**Re: Professional Paint Supply-Storage Building Addition
3921 Singer Blvd NE
Grading & Drainage Plan (E17D029A)
Engineer Stamp Date 1/6/2016**

DRAINAGE AND TRANSPORTATION INFORMATION SHEET (REV 09/2015)

RE: **Professional Paint Supply-Storage Building Addition
Grading & Drainage Plan
Engineer's Stamp Date 8/20/2015 (File: E17D029A)**

Sheet Title
 GRADING & DRAINAGE PLAN
 Drawn By: B. J. Montoya Checked By:

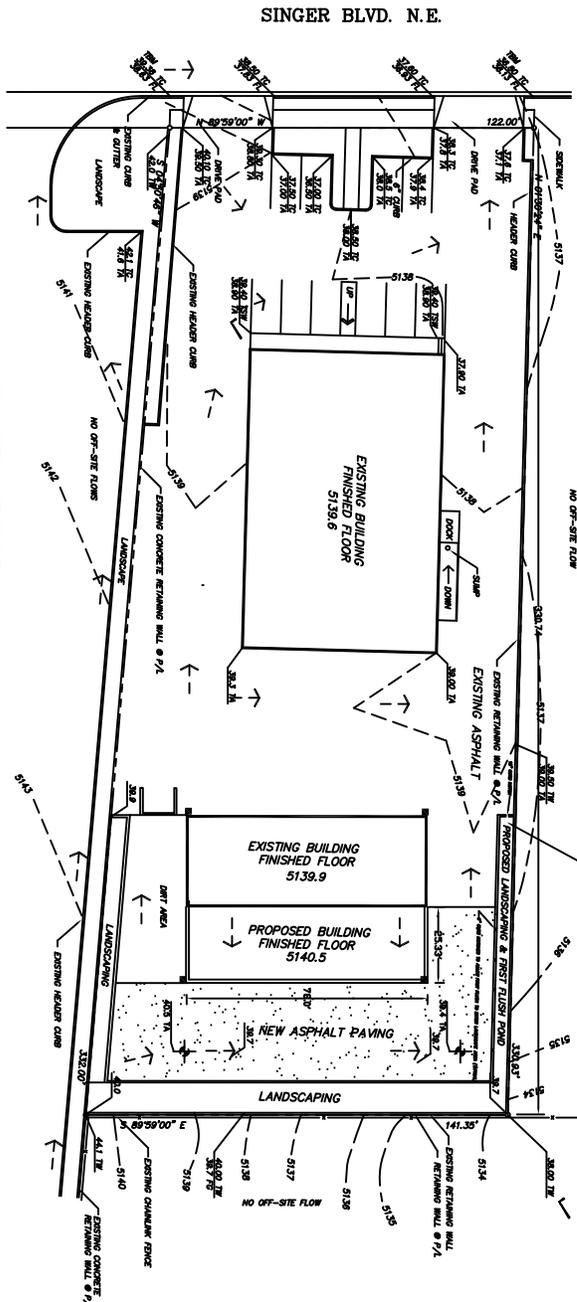
1. The City's "First Flush" requirement must be met for all new construction after May, 2014, <https://www.cabq.gov/planning/documents/SignificantDrainageOrdinanceChanges0414.pdf>. The calculation of first flush volume for this site would only be based on the area that is disturbed with the new construction.
2. Please indicate the limits of new paving on the plan
